**OXFORDSHIRE COUNTY COUNCIL’S RESPONSE TO CONSULTATION
ON THE FOLLOWING DEVELOPMENT PROPOSAL**

Application no: 21/03426/OUT

Proposal: Outline planning application for up to 78 dwellings and associated open space with all matters reserved other than access

Location: Land Opposite Hanwell Fields Recreation Adj To, Dukes Meadow Drive, Banbury

Proposed Site Access  
MAC drawing no. 340-TA114 Rev A

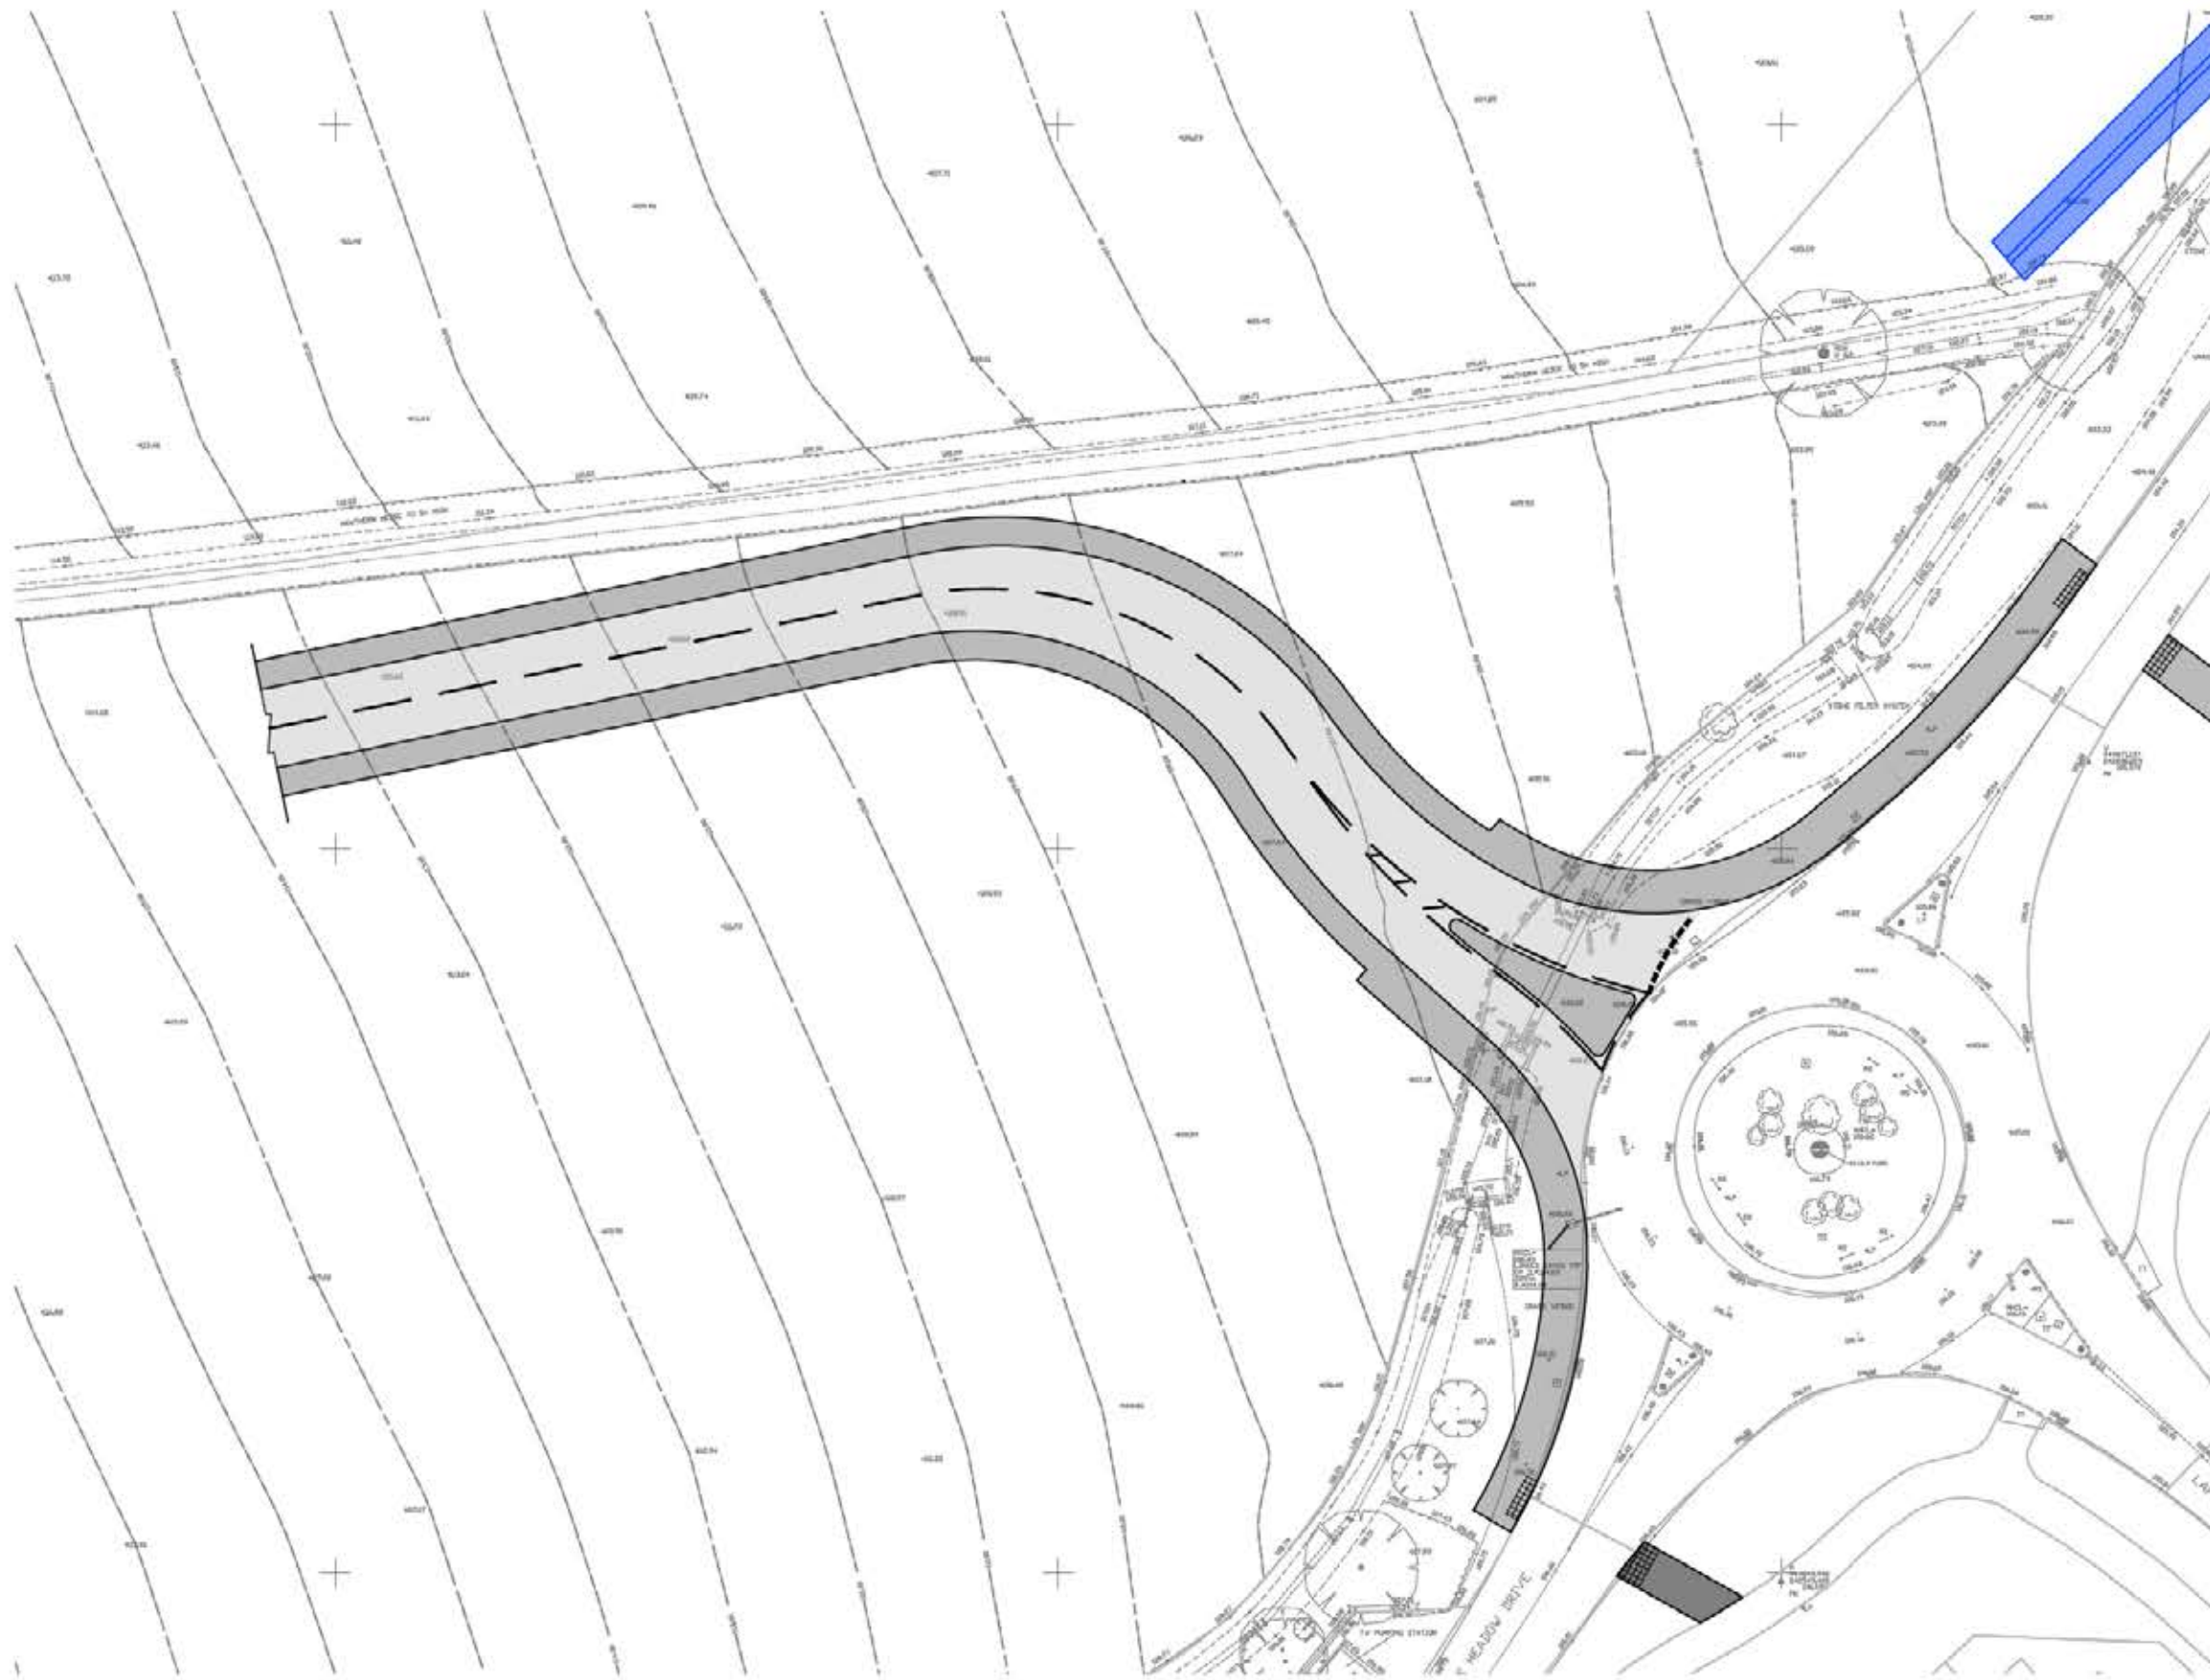
The development is currently primarily accessed via a 3m wide shared use path either side of the main vehicular access off the Dukes Meadow Drive roundabout. The submitted drawings show the 3m wide shared use path narrowing to 2m after the roundabout refuge. As far as practicable, the shared use paths should remain 3m wide along the full length of the vehicular access. The minimum width for a shared use path in LTN 1/20 is 3m. There are aspirations for an active travel corridor along Dukes Meadow Drive, accepting less than these minimum requirements would contravene this scheme and go against the Council's objectives.

There are two pedestrian links to Hanwell Fields Park outlined in the submitted documents. Limited details on these are provided. They should take the form of dropped kerb crossing points with associated tactile paving to allow pedestrians a safe way of crossing Dukes Meadow Drive. In addition, the routes from the site to the dropped kerb access points should be upgraded from grass verge to a self-binding gravel type surface at a minimum. These can be provided via section 278 agreement.

- Two dropped kerb crossing facilities to be provided at the proposed pedestrian crossing points south of the site to Hanwell Fields Park. These should include tactile paving.

- Provision of two pedestrian paths linking the site to the two dropped kerb crossing points on Dukes Meadow Drive. These should be at minimum, self-binding gravel type surfaces as this area is currently grass, not suitable for crossing by pedestrians and vulnerable users.
